From: Geoff Gibbs
Sent: 27 September 2018 08:04
To: Planning; Anita Gardner
Subject: A/114/18/PL

Application A/114/18

1 Piecemeal nature of proposal This appears to be another application for part of the site covered by the application A/27/16 substituting what appears to be a materially different and denser development of part of the area covered by A/27/16. I believe that surface water drainage remains to be resolved for A/27/16. Because of this and a range of other unresolved matters the impact of the development of the whole area covered by A/27/16 must be considered in its entirety and not in a piecemeal way. For this reason I **object** to Application A/114/18.

Drawing
SURFACE AND FOUL WATER DRAINAGE STRATEGY

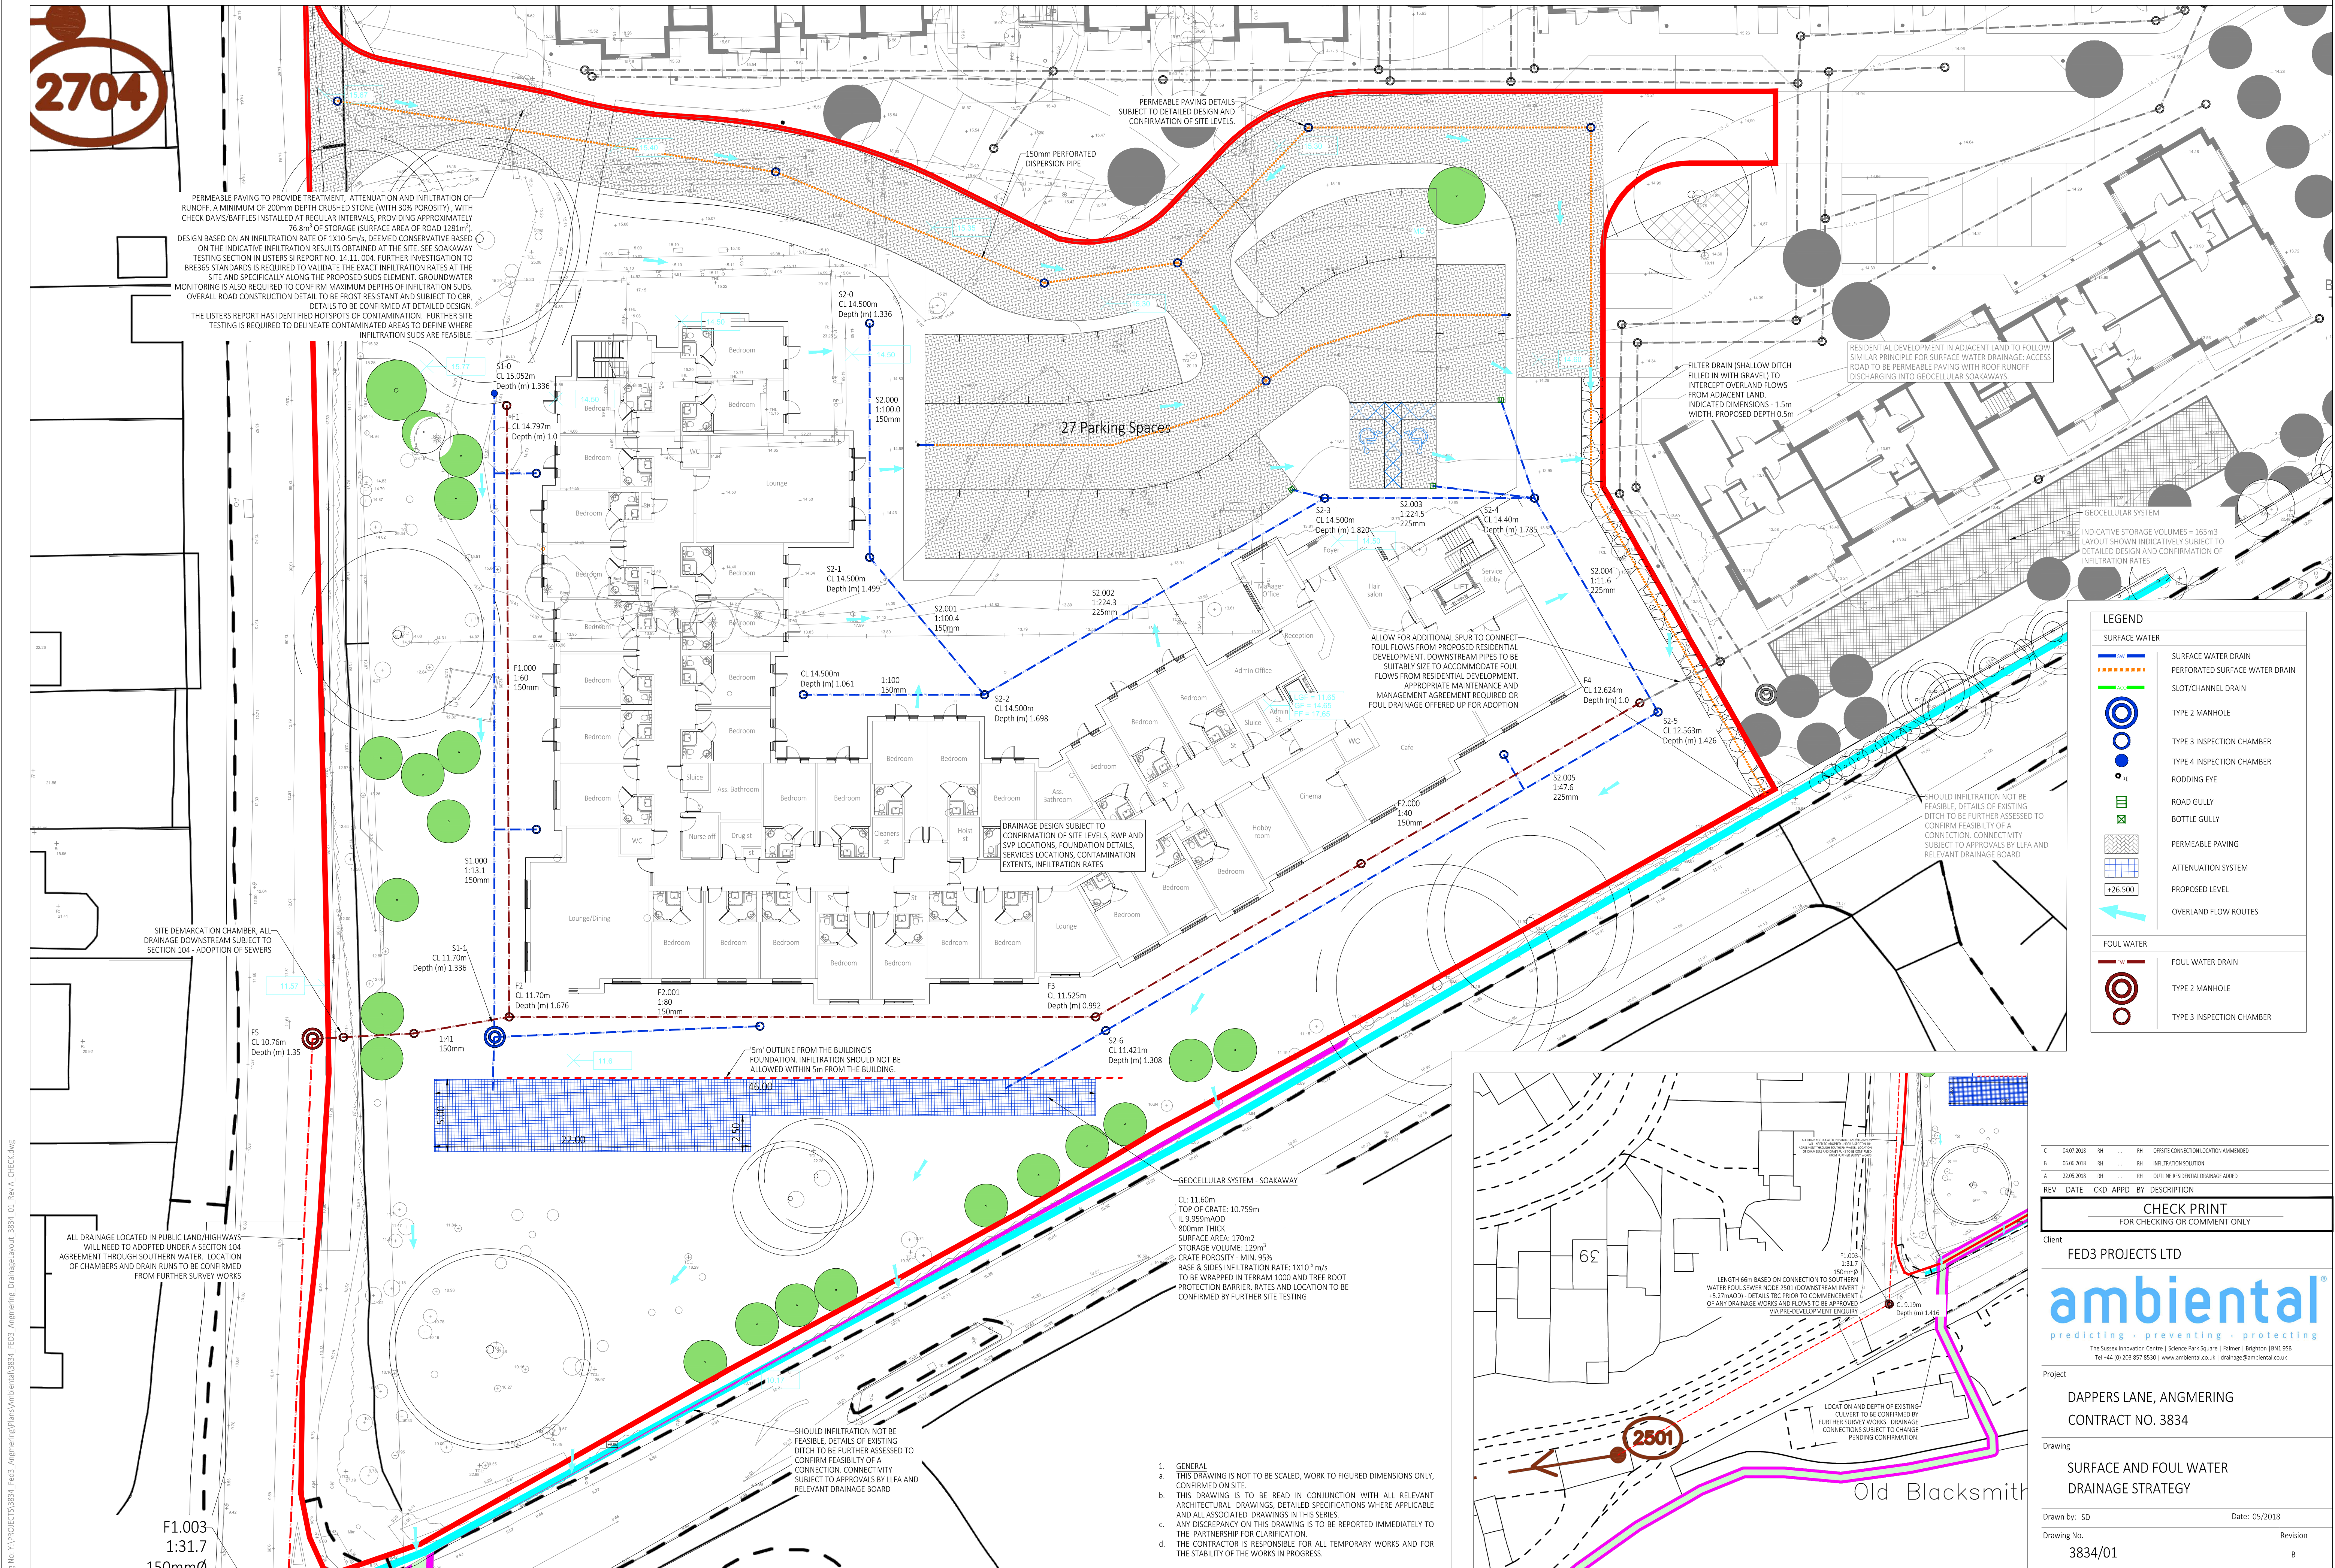
Drainage Engineers realise there is a hierarchical requirement for dealing with surface water with infiltration as the first choice. Thus the document 'SURFACE AND FOUL DRAINAGE STRATEGY 3834/01 REVB' for A/114/18 is worrying. It is a drawing and in an area where infiltration may be proposed it has the note:-

'Should infiltration not be feasible, details of existing ditch to be further assessed to confirm feasibility of a connection. Connectivity subject to approvals by LLFA and relevant drainage board.'

A statement such as this seems premature since it appears that insufficient work has been undertaken so far to demonstrate the efficacy or otherwise of infiltration. Should discharge to the 'existing ditch' (which ultimately flows into the Black Ditch upstream of the culvert), be considered it will be necessary to provide attenuation storage on site to limit the discharge to greenfield rates and it has not be indicated where such storage will be located.
